Erection of a 1410 square metres discount convenience retail food store (Use Class A1)
& parking, landscaping & other associated works.

Land at Phase 1A Oldlands Farm Shripney Road Bognor Regis

Thank you for your internet representation made on 8th January 2020 which has been recorded as '**no objection**' with the comments as follows:

PROPOSED SITE PLAN

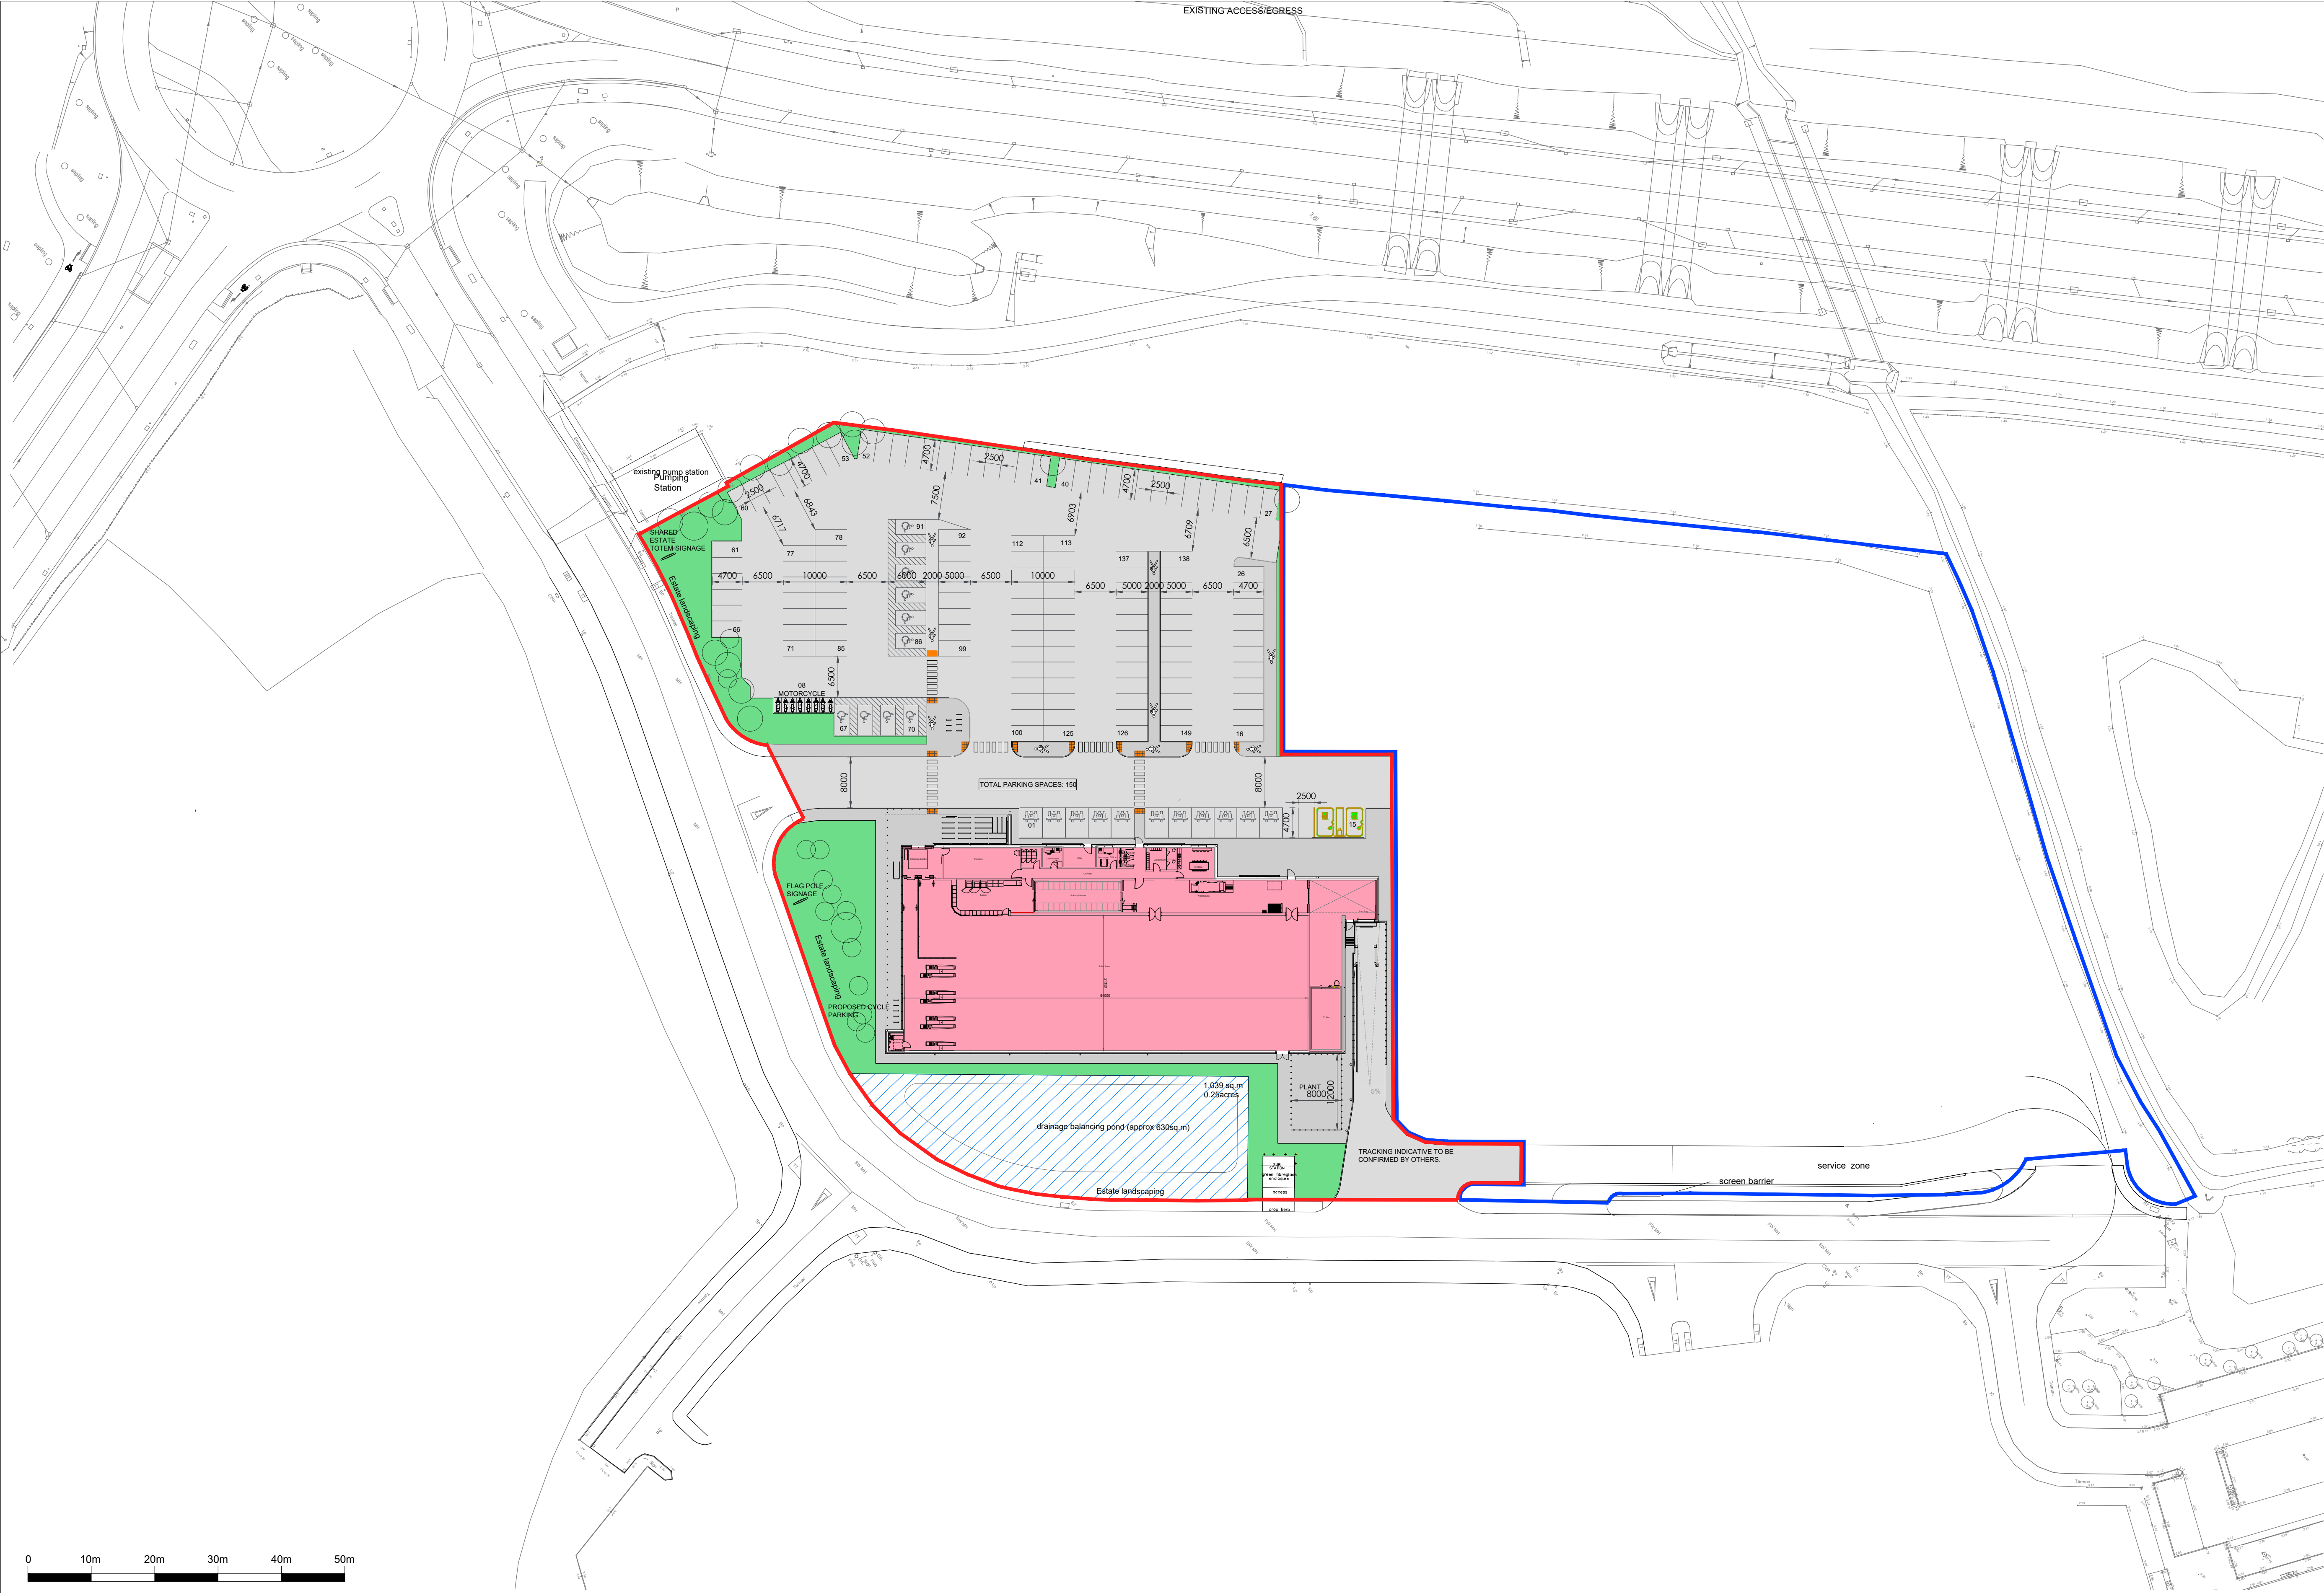
NO OBJECTION. However, there are concerns for public safety in accessing the site. Therefore, Members request that as part of the proposal either a cycle/pedestrian path is provided from the site running alongside the southbound carriageway or that a suitable pedestrian crossing for cyclists/pedestrians is installed allowing safe passage from the site across both dual-carriageways to the footpath on the northbound side.
